Santos comments on submissions received for Part 3A Modification: Narrabri Coal Seam Gas Utilisation Project

Figure 2-1 CSG infrastructure

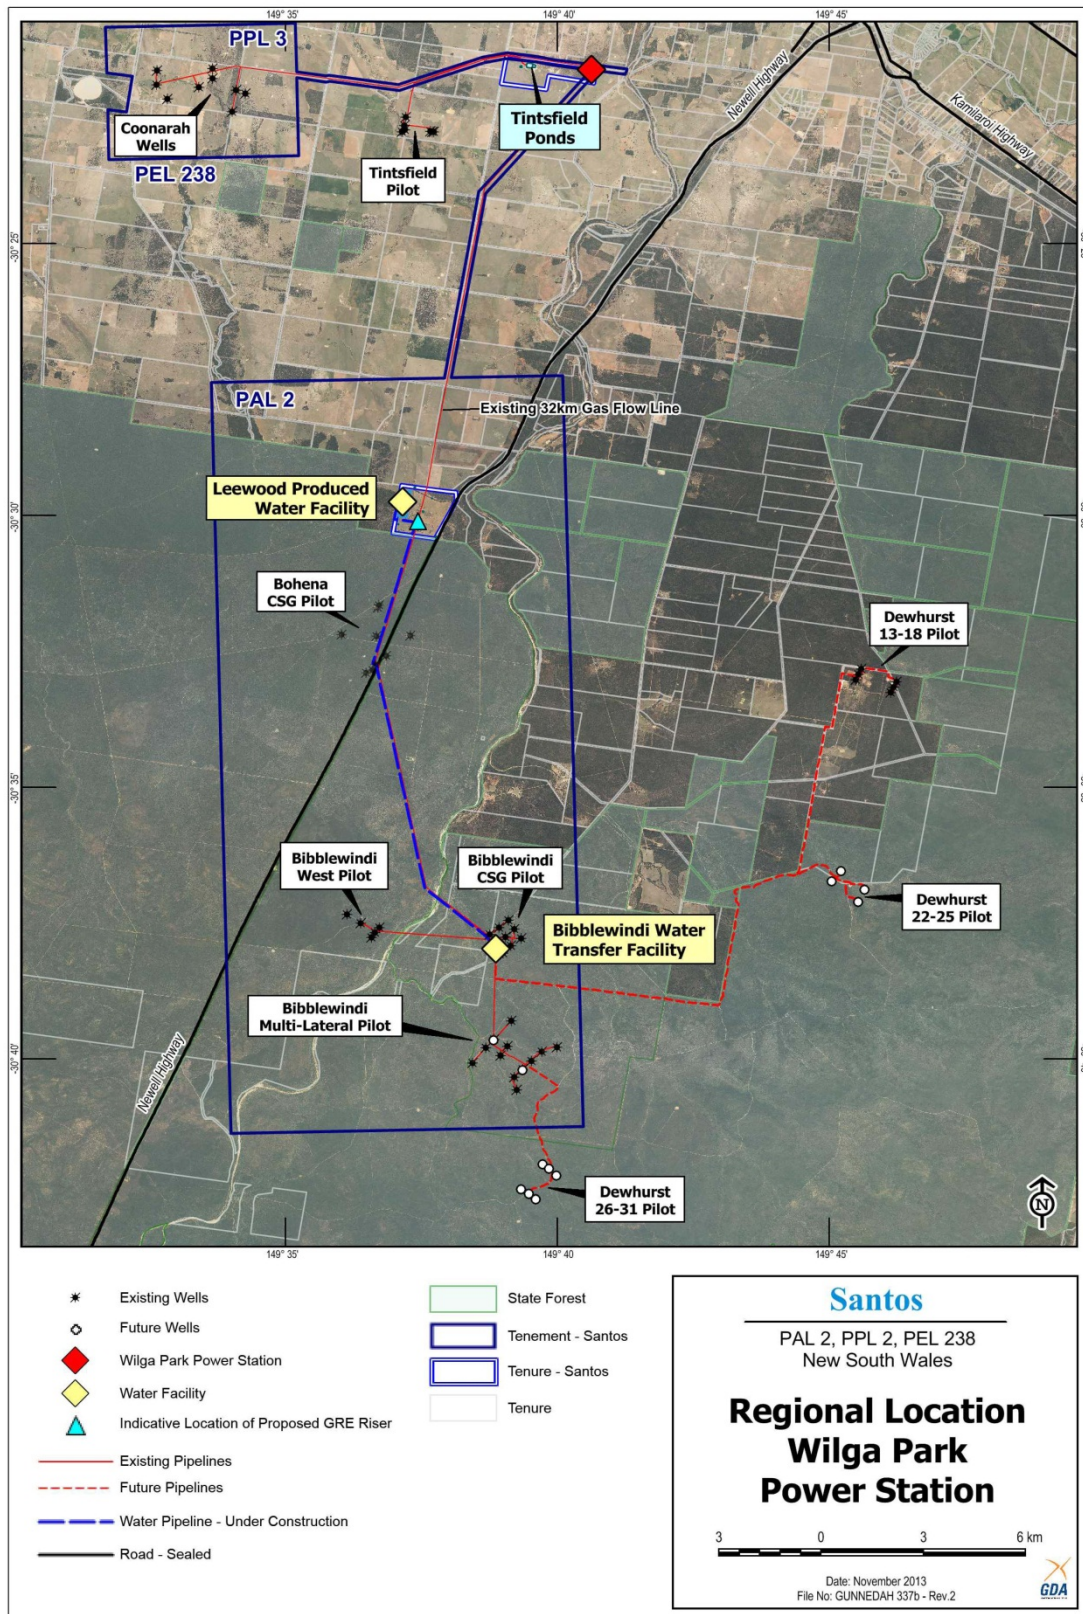
Submission detail (where relevant for Santos to address)	Santos Comment
8	Some of the wells in PAL 2 are also not on the list as contained in the Modification 3 Application.	As per above comment for issue 6, Santos is seeking approval to allow gas from all existing and future CSG wells within PAL2 and PPL3 at the Power Station. Section 3.2 of the modification application identifies the existing pilot wells within PAL 2, including the Bibblewindi Multi-Lateral Pilot and Bibblewindi West Pilot, from which it is intended to send gas to Wilga Park Power Station. The wells that make up these pilots are identified in section 2.2 of the modification application.
9	Concerns with the potential for corrosion. What measures and inspections will be undertaken to ensure that there will be no possible accidents due to natural dissimilar metal reaction.	There are extensive conditions relating to the design, installation, inspection, operation and maintenance of gas pipelines within PAL2. These conditions are reflective of the requirements of the relevant Australian Standards. In addition, Santos has its own design standards which are adhered to and these always meet or exceed Australian Standards. The proposed riser will be installed in accordance with all relevant conditions and requirements. Corrosion of materials is specifically addressed by physical inspection as required under the design standards. Inspection regimes typically can include magnetic particle, ultrasonic and radiography, depending on the type of material that is inspected.
